**Our ref:** NO/2012/104356/01-L01  
**Your ref:** 3/2012/0818  
**Date:** 11 October 2012

**PROPOSED CAR PORT TO REAR OF GARAGE TO PROVIDE COVERED STORAGE AREA. BROOKSIDE GARAGE LTD., PADIHAM ROAD, SABDEN, LANCS, BB7 9EW.**

FW2012 - 02

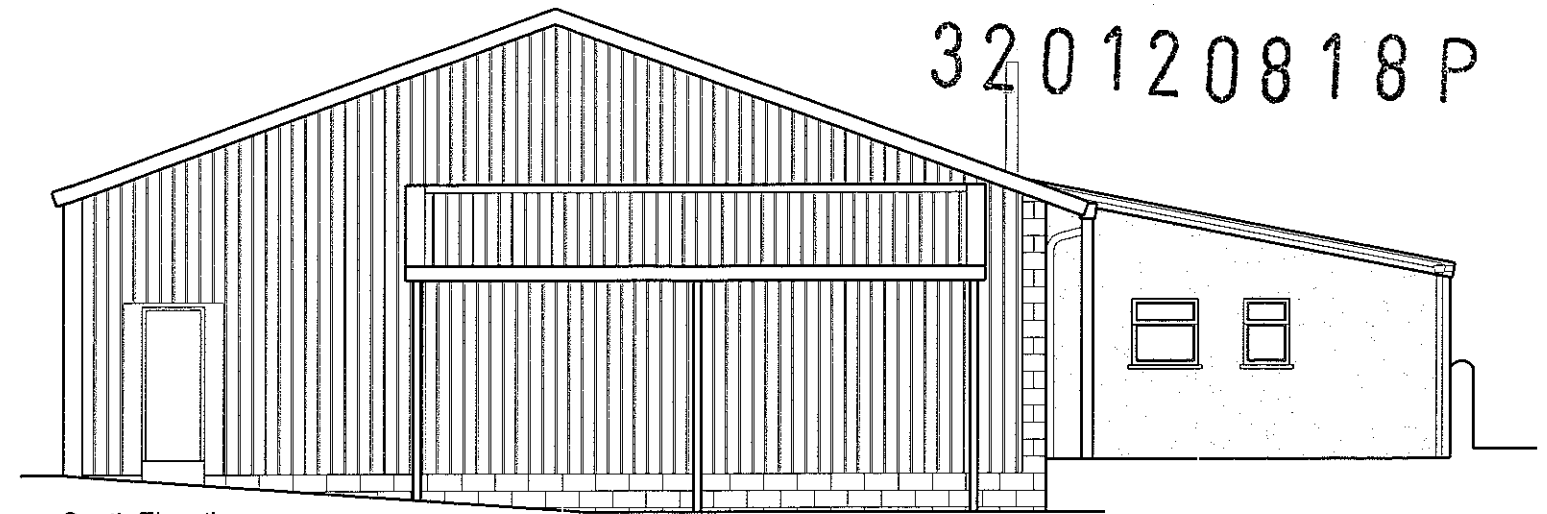
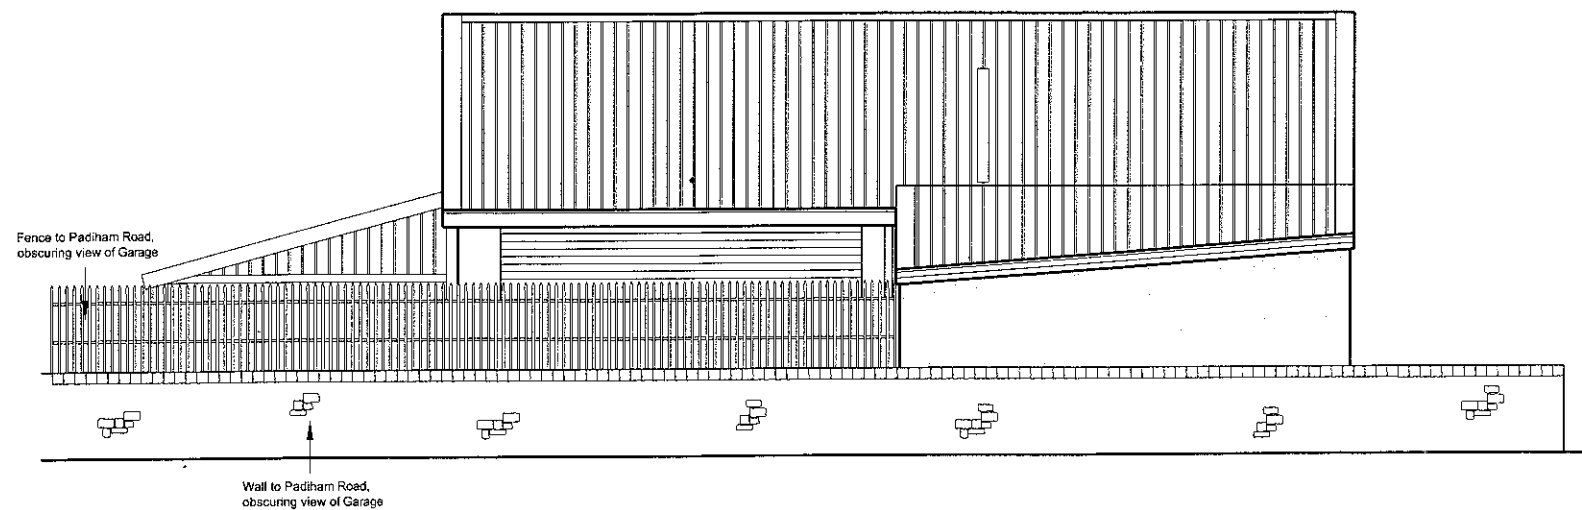
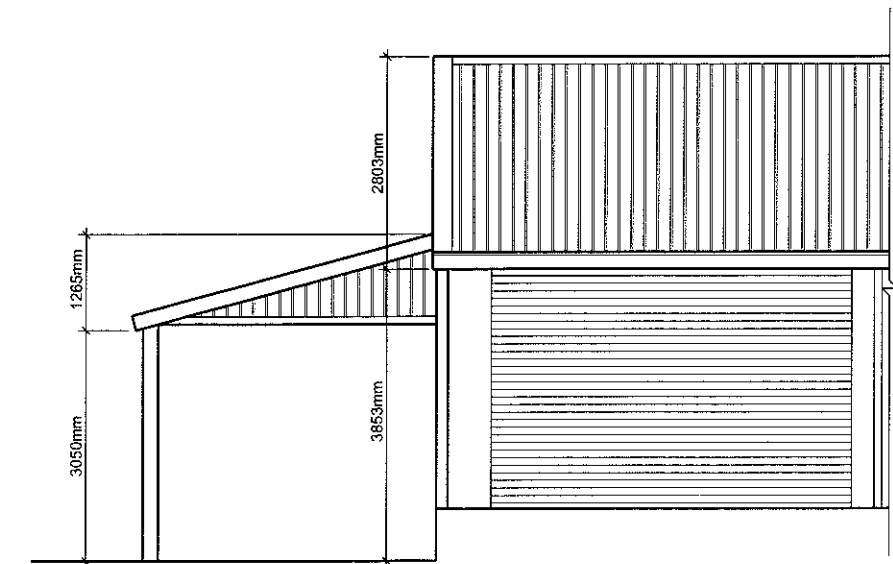
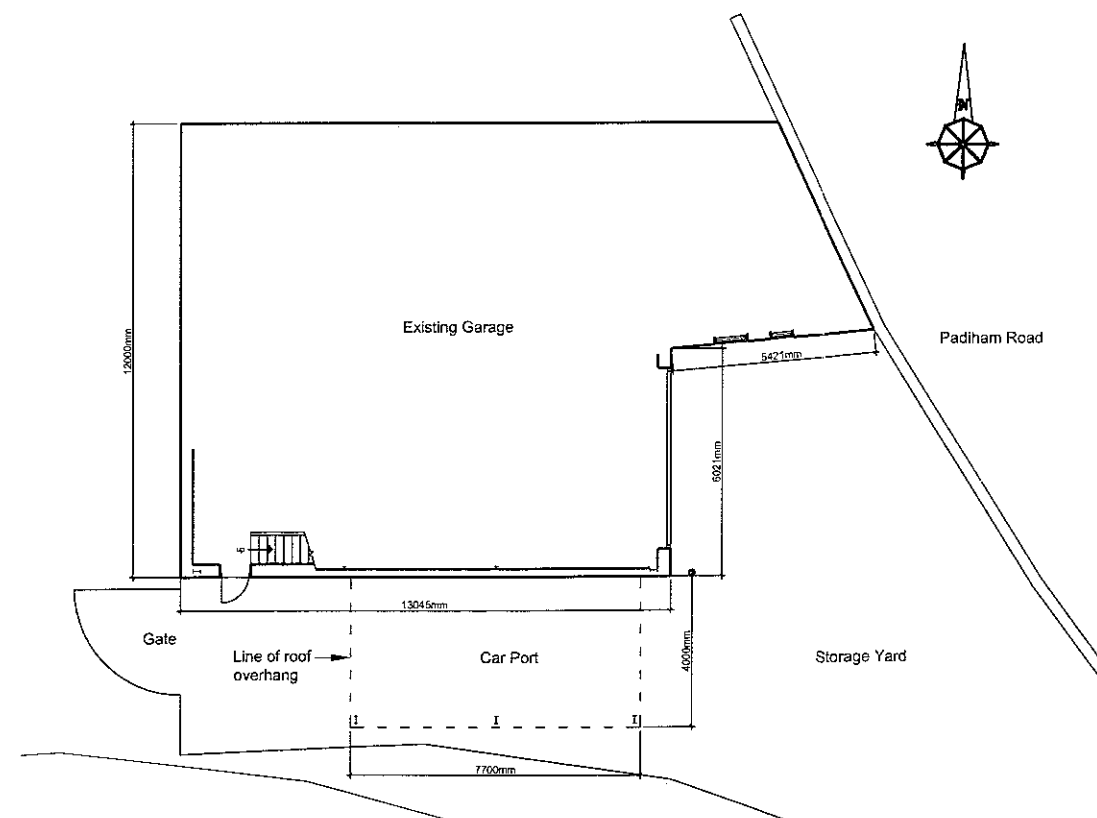
Sabden Brook which adjoins the site, is a designated Main River and is therefore subject to Land Drainage Byelaws. In particular, byelaw 7 states that no trees or shrubs may be planted, nor fences, buildings, pipelines or any other structure erected within 8 metres of the top of any bank/retaining wall of the watercourse without prior written Consent being obtained from the Environment Agency. Full details of such works must be submitted to us for consideration.

In order to protect the watercourse, the applicant shall take appropriate measures to prevent pollutants from entering into the watercourse.
